Recommendation Report for Planning Permission for Works or Extension to a Dwelling

REF NO: AW/138/26/HH

LOCATION: 4 Regis Avenue
Aldwick
PO21 4HQ

PROPOSAL: Proposed front first floor dormer extension and fenestration changes.

PROPOSED ELEVATIONS

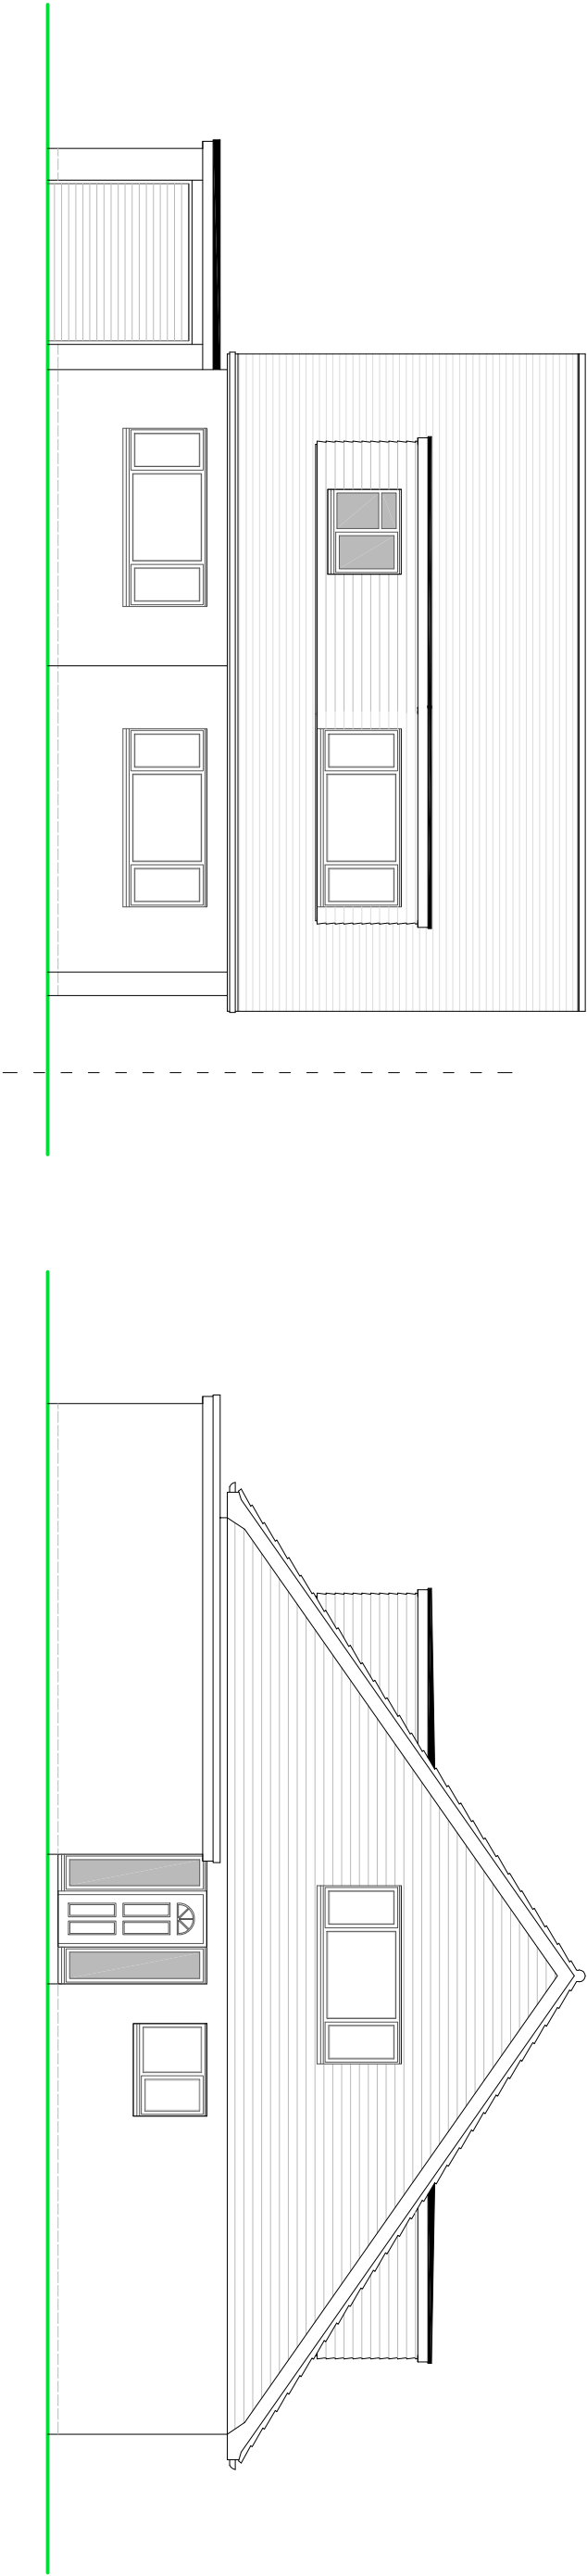
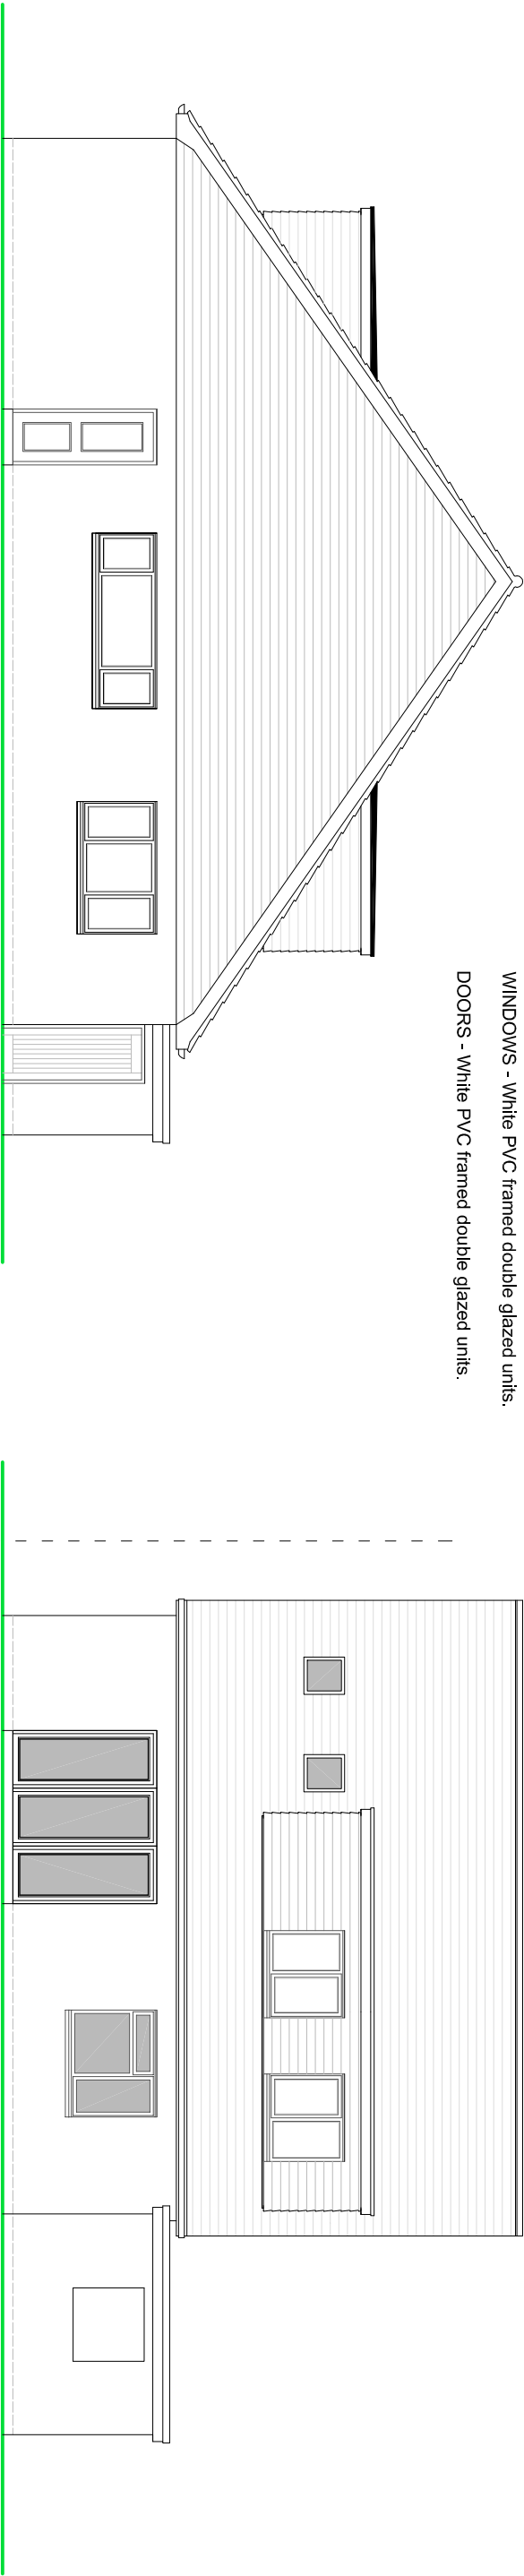
The existing dormer within the front (north) elevation would be extended from approximately 3m to a maximum width of 6.9m. The height and depth of the dormer would remain unchanged at approximately 1.7m and 2.6m respectively. The extension would be finished in materials to match the existing cladding and would incorporate an additional two-pane window.

The extended dormer would be prominent within the street scene and would increase the overall massing of the roof slope. However, it would remain subordinate to the host dwelling, retaining a set-down from the roof ridge in accordance with the Arun Design Guide (ADG). The proposed extended dormer would remain contained within the existing front roof slope, and front dormers are a common characteristic of properties within the surrounding area. As such, the proposal would appear consistent with the established character of the street scene and would not result in visual harm.

Alterations to the existing fenestration are also proposed. On the east elevation, the existing entrance door would be replaced with a new door flanked by glazed side panels. The rear elevation would incorporate new glazed patio doors and a two-pane window to facilitate internal alterations. In addition, two rooflights would be installed within the southern roof slope. The windows would visually match the host dwelling and as such would be acceptable. The proposed internal alterations would not result in any additional external changes and as such, would not result in harm to visual amenity.

The dormer extension would be set in approximately 5.1m from the neighbouring property to the east. Given its modest height and scale, together with the separation distance between properties, the proposal would not result in overbearing or overshadowing of neighbouring occupiers. To the west, the extension would be largely screened by the existing dormer structure and would not result in overshadowing impacts.

The additional window within the extended dormer would overlook the front amenity area and public highway. The presence of the highway between properties would limit opportunities for overlooking, and the outlook provided would be broadly comparable to that of the existing first-floor window. As such, there would be no loss of privacy to neighbouring occupiers.
